DRB Project Case #: 1007572

Subdivision Name: GLENWAY PARK ADDN BLOCK 8 LOT 28A

DRB Application No.: 08DRB-70506

Project Name: GLENWAY PARK ADDITION

**PLAT OF
LOT 28-A, BLOCK 8
GLENWAY PARK ADDITION
PROJECTED SECTION 7, T 10 N., R. 3 E., N.M.P.M.
TOWN OF ALBUQUERQUE GRANT
CITY OF ALBUQUERQUE
BERNALILLO COUNTY, NEW MEXICO
OCTOBER 2008
SHEET 2 OF 2**

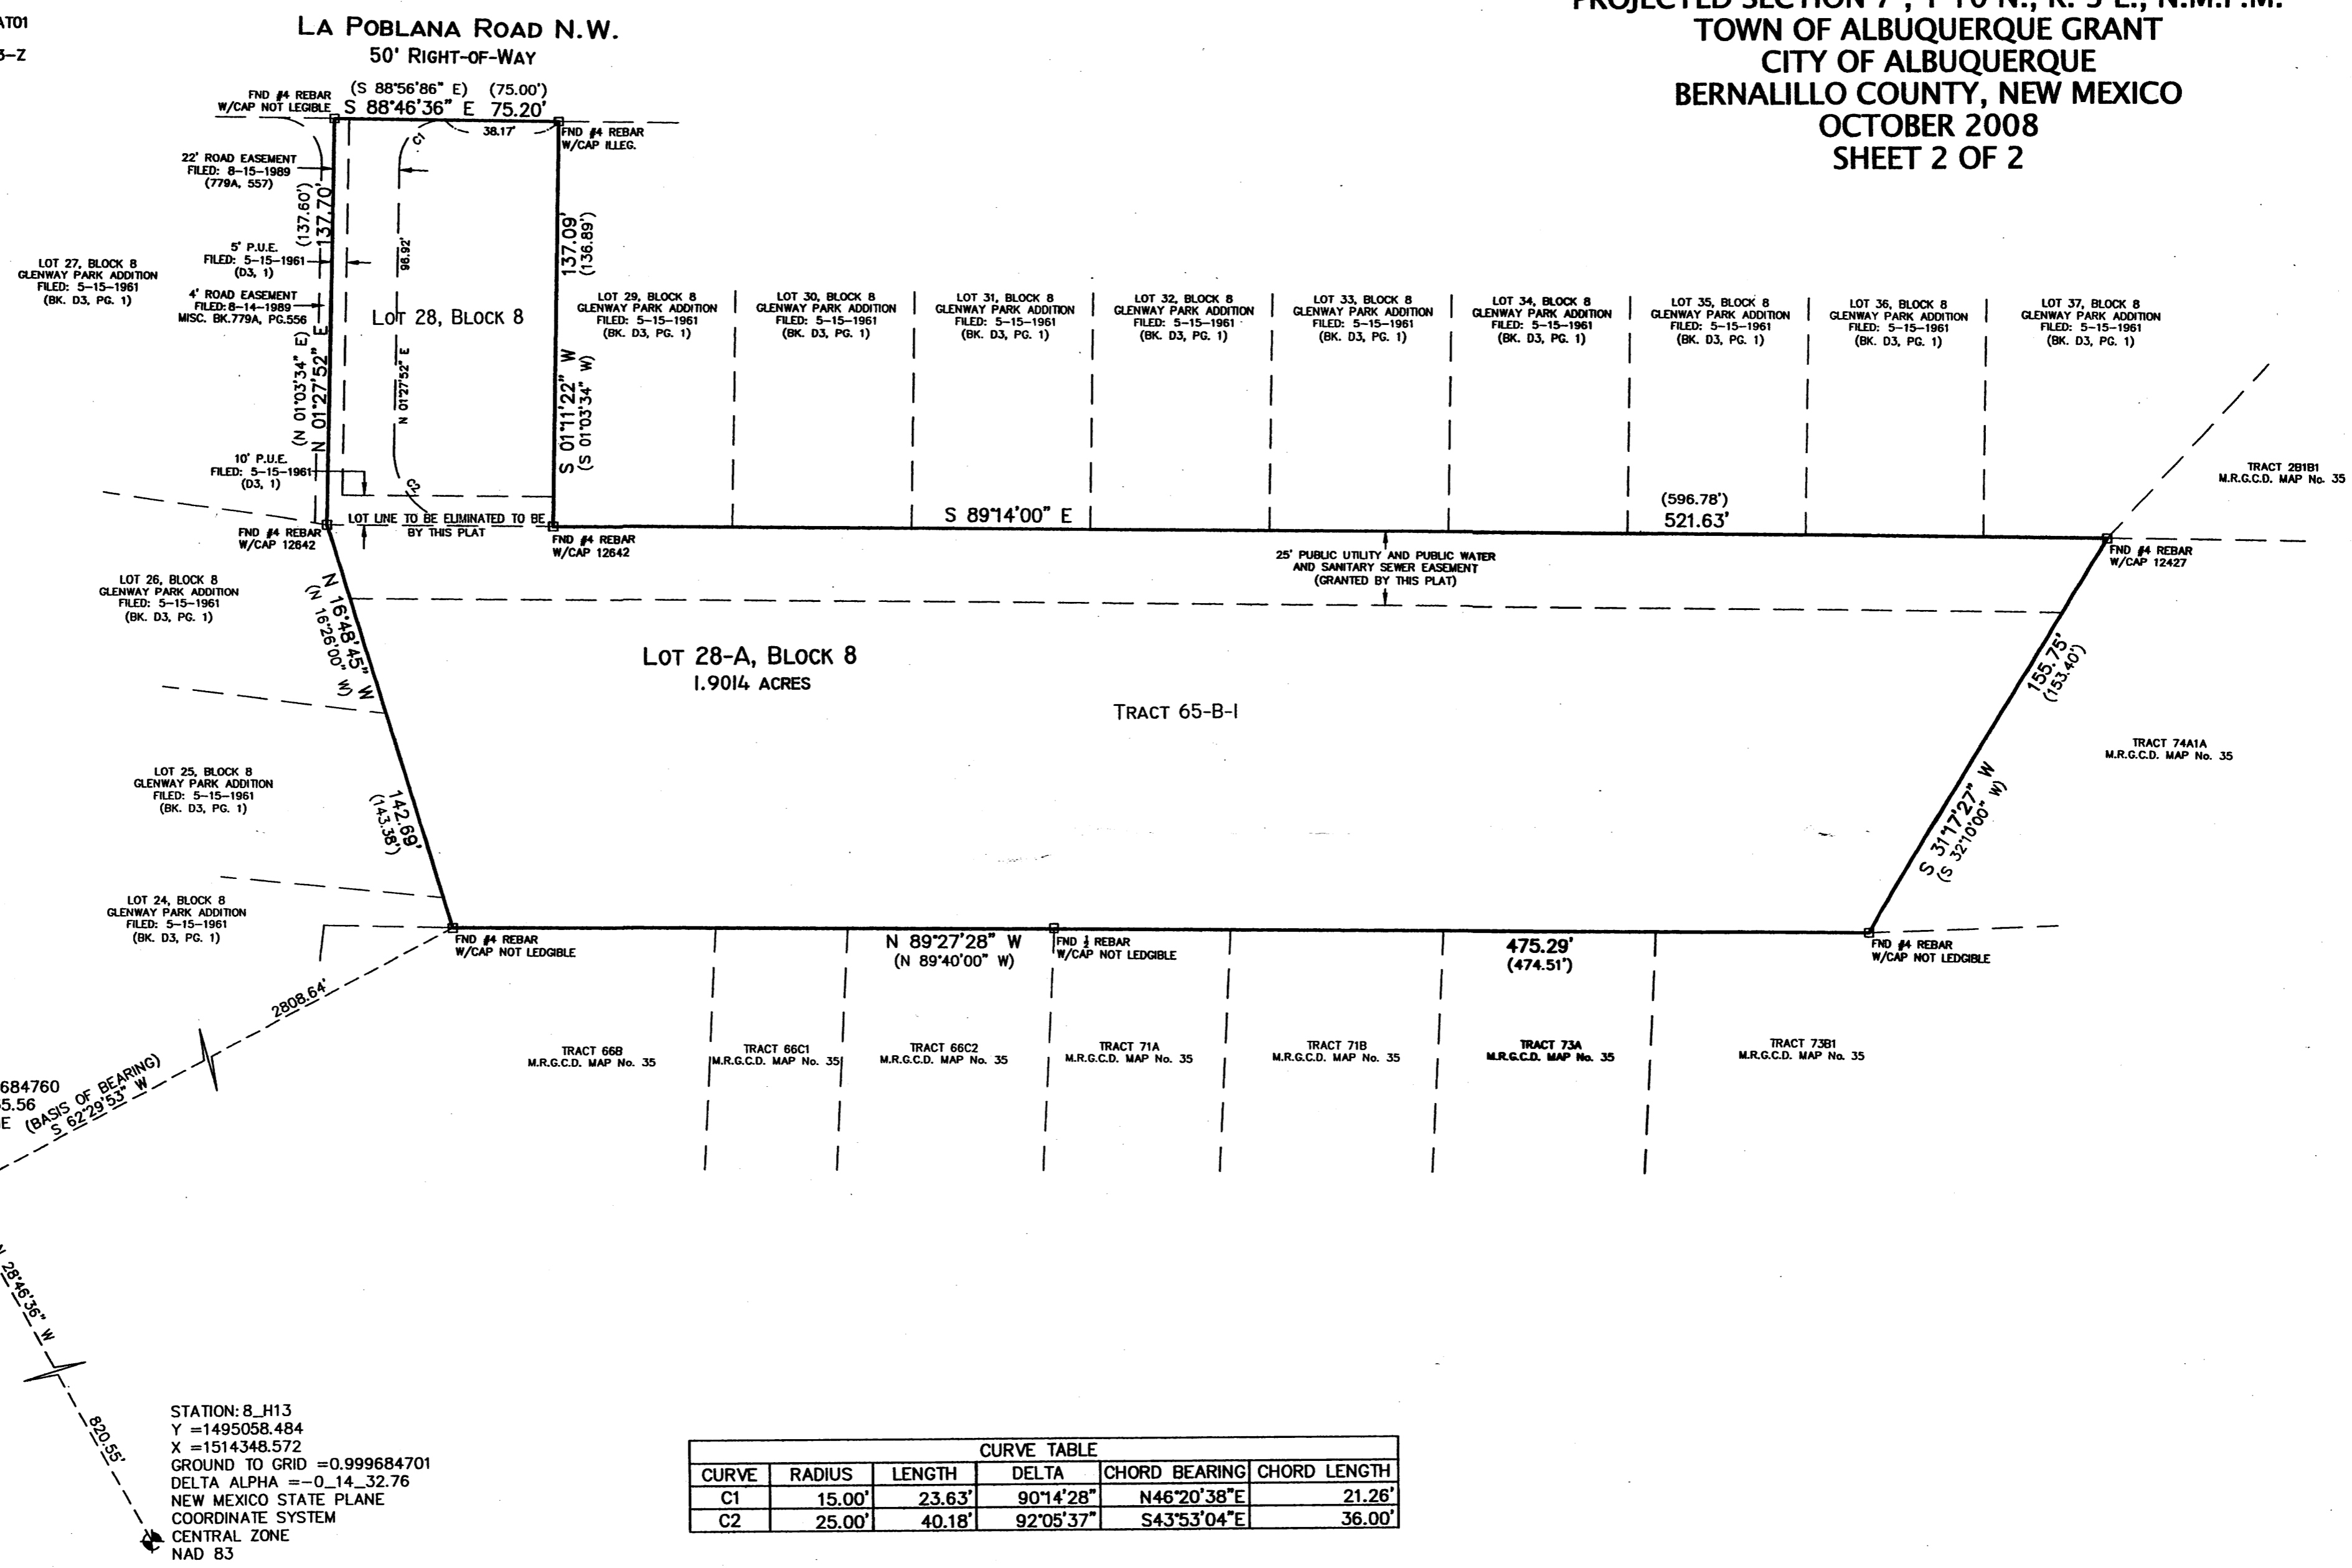
TRANSPORTATION: - Exhibit ; copies of easements

PLANNING (Last to sign): - remove "Public Easement"

JOHN JARRETT GARCIA request(s) the above action(s) for all or a portion of Lot(s) 28-A, Block(s) 8, **GLENWAY PARK ADDITION**, zoned R-1, located on LA POBLANA RD NW BETWEEN SAN IYSIDRO NW AND 12TH ST NW containing approximately 1.869 acre(s). (H-13) **THE PRELIMINARY/FINAL PLAT WAS APPROVED WITH FINAL SIGN OFF DELEGATED TO TRANSPORTATION FOR EXHIBIT AND VERIFICATION/COPIES OF EASEMENTS, AND TO PLANNING FOR REMOVAL OF "PUBLIC EASEMENT."**
